BOWMANS CREEK **WIND FARM**
Response to Additional Information Request

23 February 2022

Bowmans Creek Wind Farm LVIA (SSD-10315) response to DPIE request for additional information

Photomontage view from F18-1 Dwelling: Approximate distance to turbine T59 is 3,260 metres **Viewpoint location:** E: 131119 N: 6427300 **Turbine dimensions:** 150m hub, 220m tip

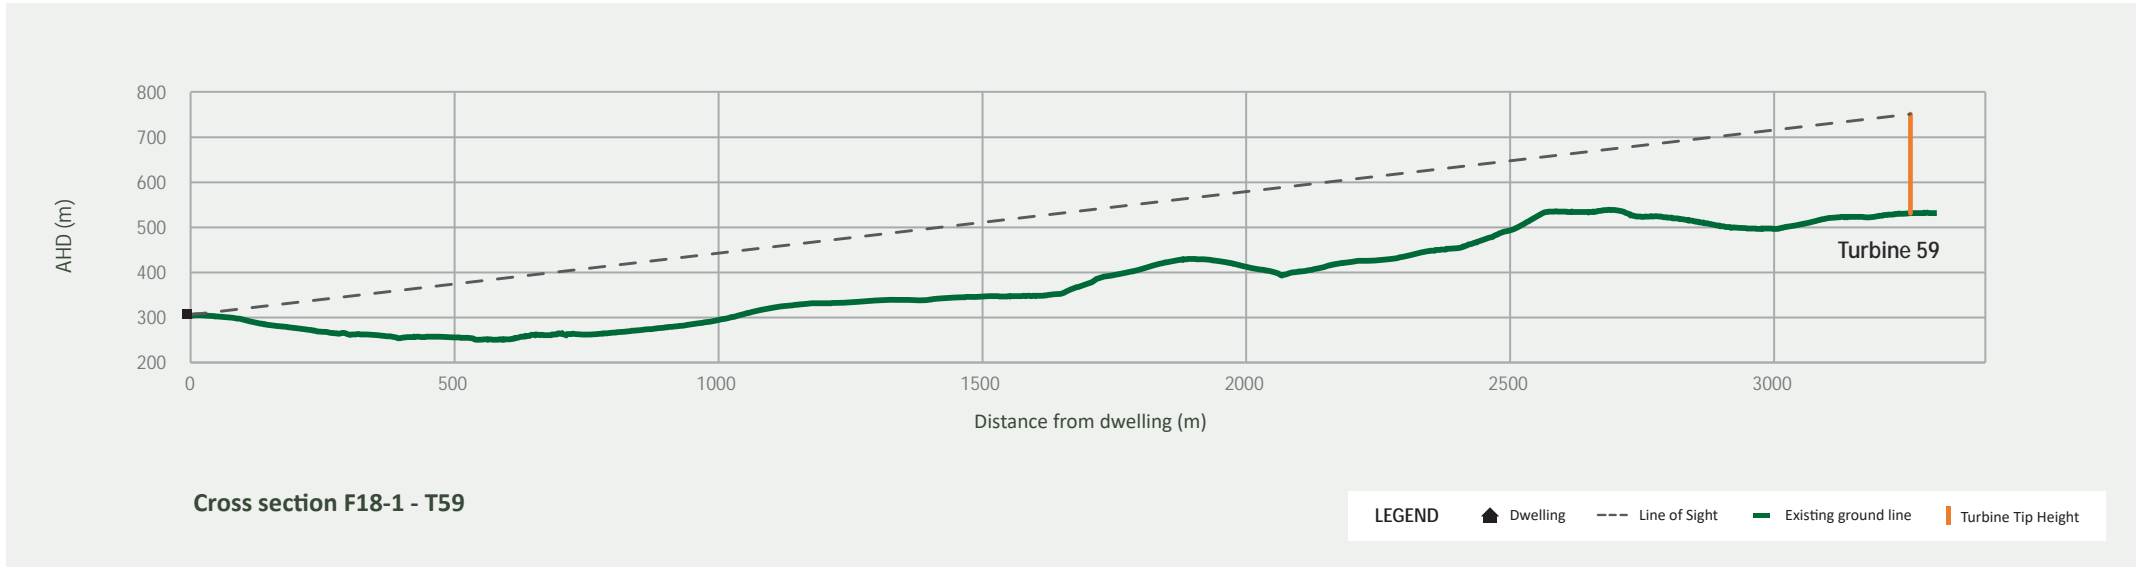
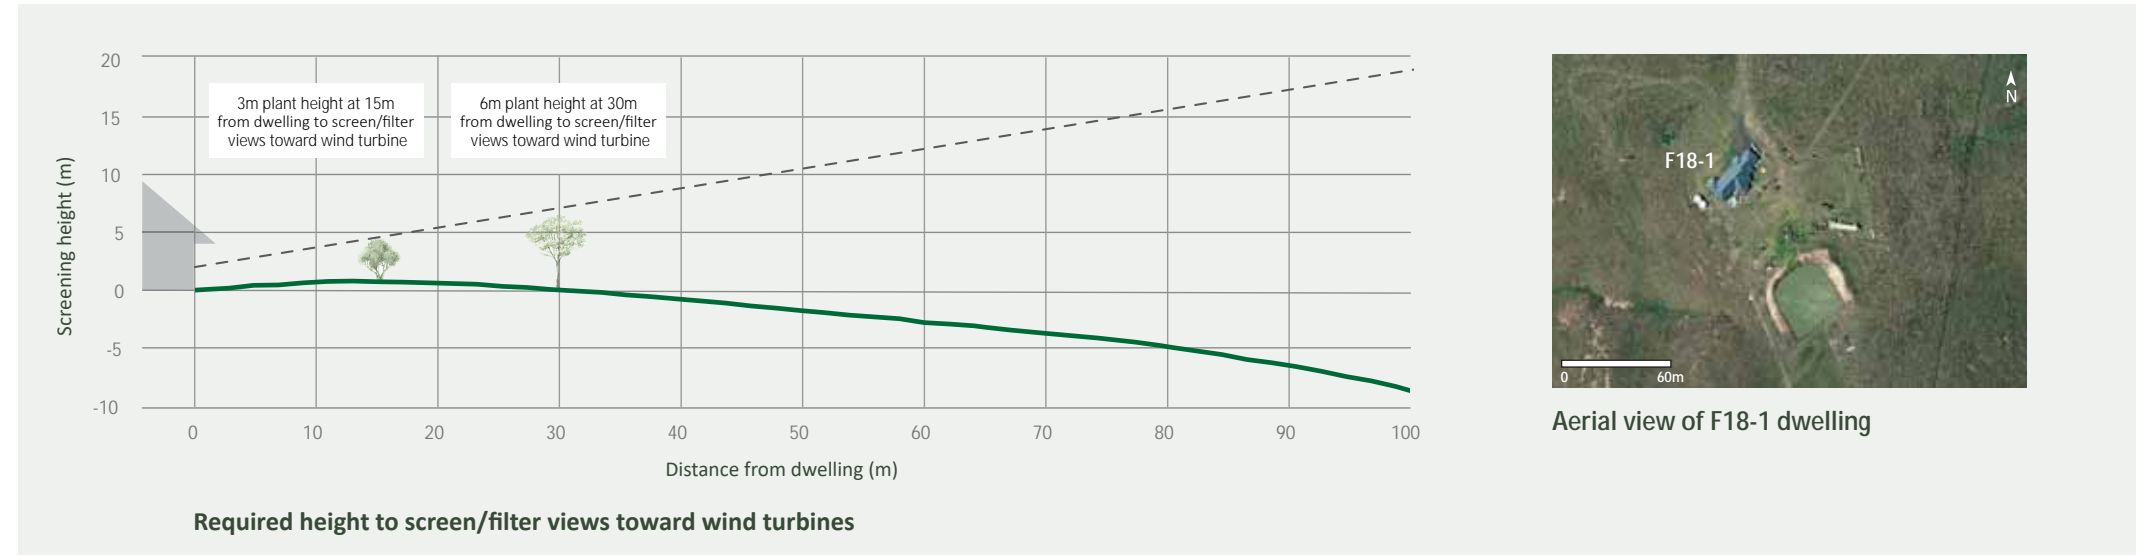
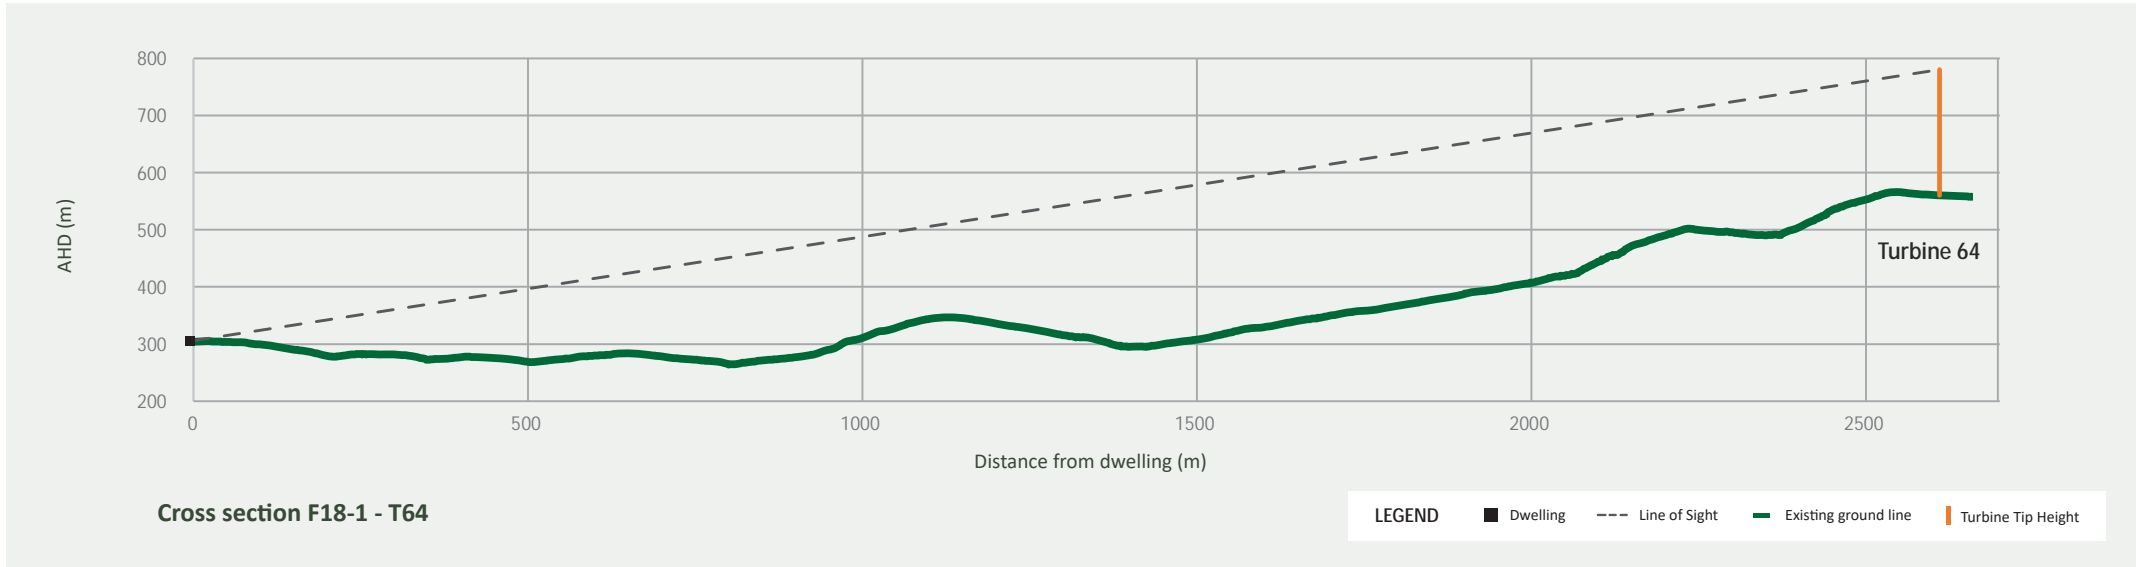
The cross sections prepared for non associated dwellings below the black line illustrate that planting less than 10m in height, at a distance of 30m from dwellings, would screen views toward wind turbines in elevated locations. The height of effective screen planting will gradually reduce if planting can be installed closer to dwellings. In some locations effective screening height may be reduced to around 5m or below, where larger trees may be replaced by small trees or large shrubs closer to dwellings (between 10m to 15m).
